Beecroft Cheltenham  
History Group

Director, Infrastructure Projects  
Epping to Thornleigh Third Track Project SSI 5132  
NSW Department of Planning and Infrastructure  
GPO Box 39  
SYDNEY NSW 2001

**Heritage Assessment Report – Environmental Impact Statement  
Report**

**Response to the Historic Cultural Heritage Assessment commissioned for the Northern Sydney Freight Corridor: Epping to Thornleigh Third Track Project. This assessment was undertaken by Artefact Heritage is dated September 2012.<sup>1</sup>**

Concept design drawing of proposed changes to Beecroft Station (Parsons Brinckerhoff 9/3/12). Former side platform shaded in pink.

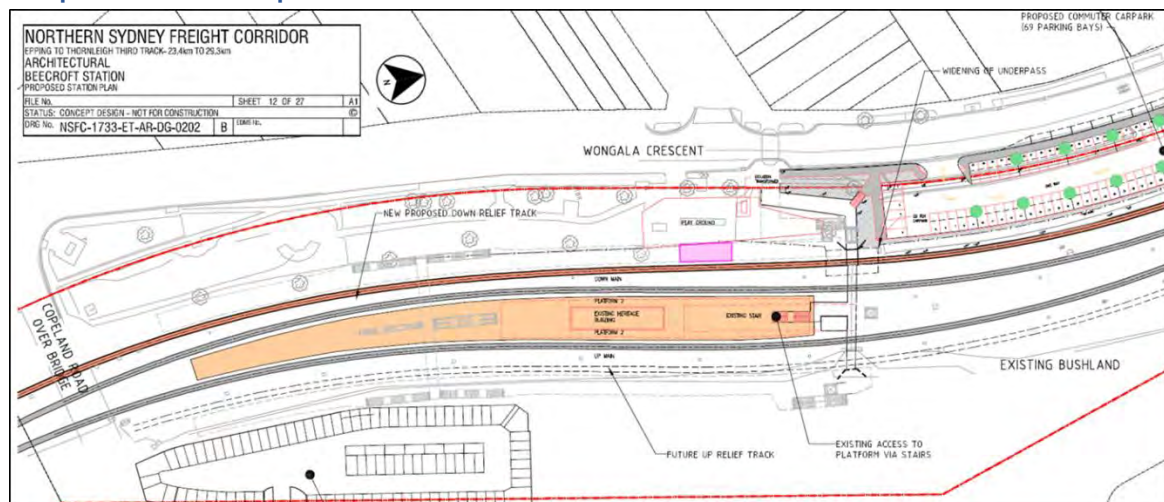
Beecroft Railway Station precinct comprises not just the station but also the neighbouring parkland, children's playground and the heritage plantings. The large pines in this area date from possibly the 1898 planting supplied by the Botanic Gardens. The removal of 2 trees removes one third of these trees and yet despite this being an apparently significant numerical proportion of the trees being removed, the remaining trees are said to "effectively maintain the landscape qualities of the park and the visual connection with the establishment of the gardens in the late 19<sup>th</sup> century."<sup>13</sup> It would not seem unreasonable to conclude that a similar comment would be made if all but two trees were left in the middle of railway tracks constructed on either side of the remaining trees. The approach of leaving the façade of a building as a way of maintaining heritage is strongly criticised in the NSW Heritage Manual Guidelines.<sup>14</sup> Yet while the Assessment Report seeks to uphold these guidelines it says that it is acceptable to leave a much reduced landscape so that only significant trees on the street elevation remain. No arborist's report accompanies the Assessment Report despite the heritage items in question being trees rather than built structures. No mention is made of the removal of at least one replacement pine that has commenced to grow in the area of the remnant platform and has (possibly) 20 years growth.

Proposed changes at Cheltenham Station - 50 The Crescent indicated by pink shading and arrow

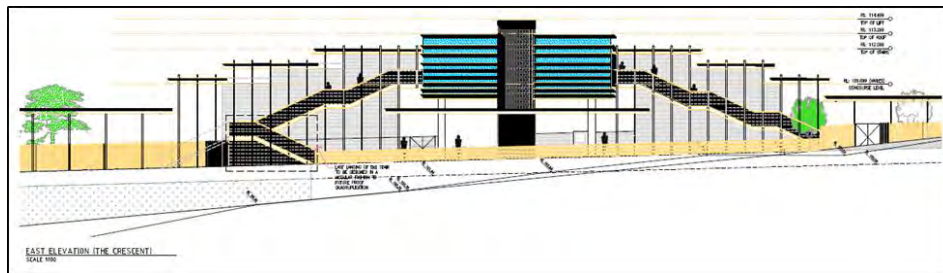
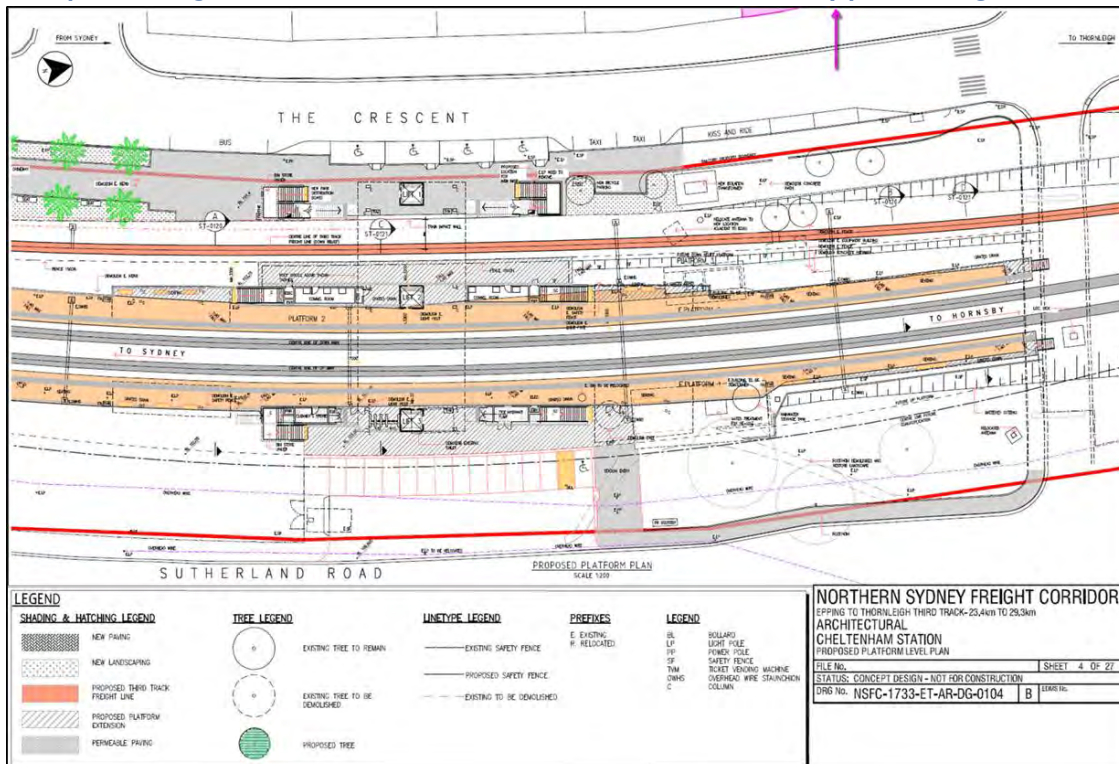
Along the Crescent (and especially opposite the station) there are a number of individually listed heritage properties. The Assessment Report acknowledges that the proposal will "impact on views from the house."<sup>22</sup> The proposal is for a two storey development increasing railway lines by a third, increasing the amount of diesel freight traffic, with significant parking alteration and the removal of almost all existing vegetation within a residential part of a heritage conservation area. Of this impact on the heritage significance of this precinct the Assessment Report states that "while not ideal would not have a significant negative impact."<sup>23</sup> This assertion is difficult to reconcile with the physical change being wrought.

The bulk and size of the proposed development, especially in the absence of any other building of a non-residential nature in the locality demonstrably and detrimentally impacts on the heritage of not just the conservation area (of which the railway station forms part) but of the individual items that will now be denuded of their garden and bush land settings.

The building of a platform at Cheltenham had not originally even been contemplated. The surveyors ruled out a platform because of the steep grade on the lines. It was not until 1898 that prominent Cheltenham resident William Chorley lobbied for the construction of a railway station. Mr Chorley and another Cheltenham resident Mr George Rattray each personally contributed one hundred pounds (almost fifty percent of the total cost) to the construction of the platforms. Not only did Mr Chorley desire a platform to avoid a horse and buggy ride to the nearest platform but it also permitted him to more readily market residential blocks on the eastern side of the railway.<sup>24</sup> The essential heritage elements of the station precinct are therefore of a small, later considered, site entirely intended as an adjunct to a purely local clientele. When opened "Mrs Chorley decorated the platform with the Union Jack and Australian flags, ferns and native flowers" not as a commercial interchange but as a personal, intimate residential siding. This is the heritage nature of this railway precinct. The images of the size and complexity of the proposed new station are entirely contrary to these heritage values. No Statement of Heritage Impact is provided to discuss any way in which the size might be modified, the design made more compatible with the heritage precinct in which it is located nor the footprint confined to its historical roots.

1943 aerial photograph showing lack of screening vegetation between Wollundry Park and the rail line (Six Viewer)

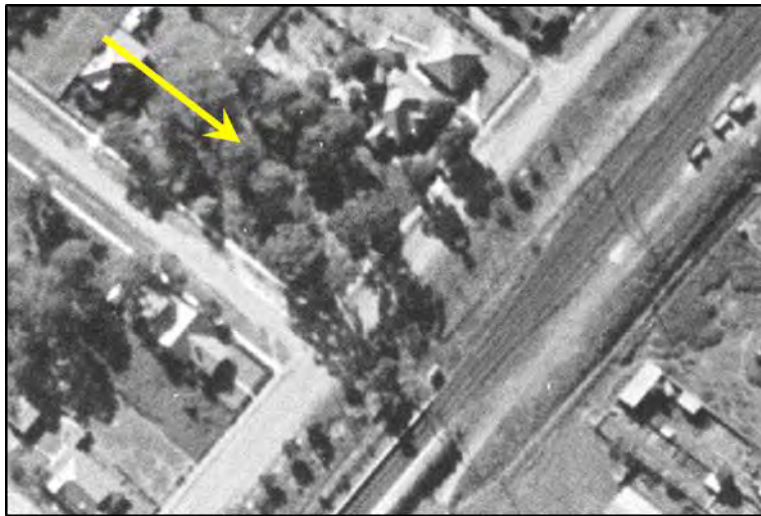
Where this will no longer be the case, such as opposite the Cheltenham Recreation Club, then a 1943 aerial photograph is used to demonstrate that at one point in the history of the area vegetation coverage along the corridor was slight then is sufficient to say that there will be no heritage impact because, in any event, "views from the club are not a vital facet of the item's heritage significance."<sup>6</sup> If material from 40 years earlier was quoted then it would be noted that the entire area along the railway corridor was described as so thickly timbered that it was not possible to determine where (in this case the Village Green but also down through Cheltenham) ended and the bush commenced.<sup>7</sup> The photograph reproduced on page 38 of the tree coverage at Beecroft was typical of the tree coverage at Cheltenham at the same time. Indeed, in 1943 large tracts of Beecroft also appeared sparsely timbered at this time – this being the end of small dairying properties in the locality and so, also the end of large scale clearing for primary industry. To suggest that the removal of vegetation in 2012 is not contrary to the heritage of the area because of a photograph in 1943 or indeed a photograph in the 1880 when the locality was known as Barren Hills because of the ravages of the timber getters, is using selective information from history to make a point. It fails to recognise that it is otherwise indisputable that one of the identified heritage items of all other heritage discussions of this area and one of the values behind classifying this as a conservation area is because of its "mature landscaping and remnant forests."<sup>8</sup>
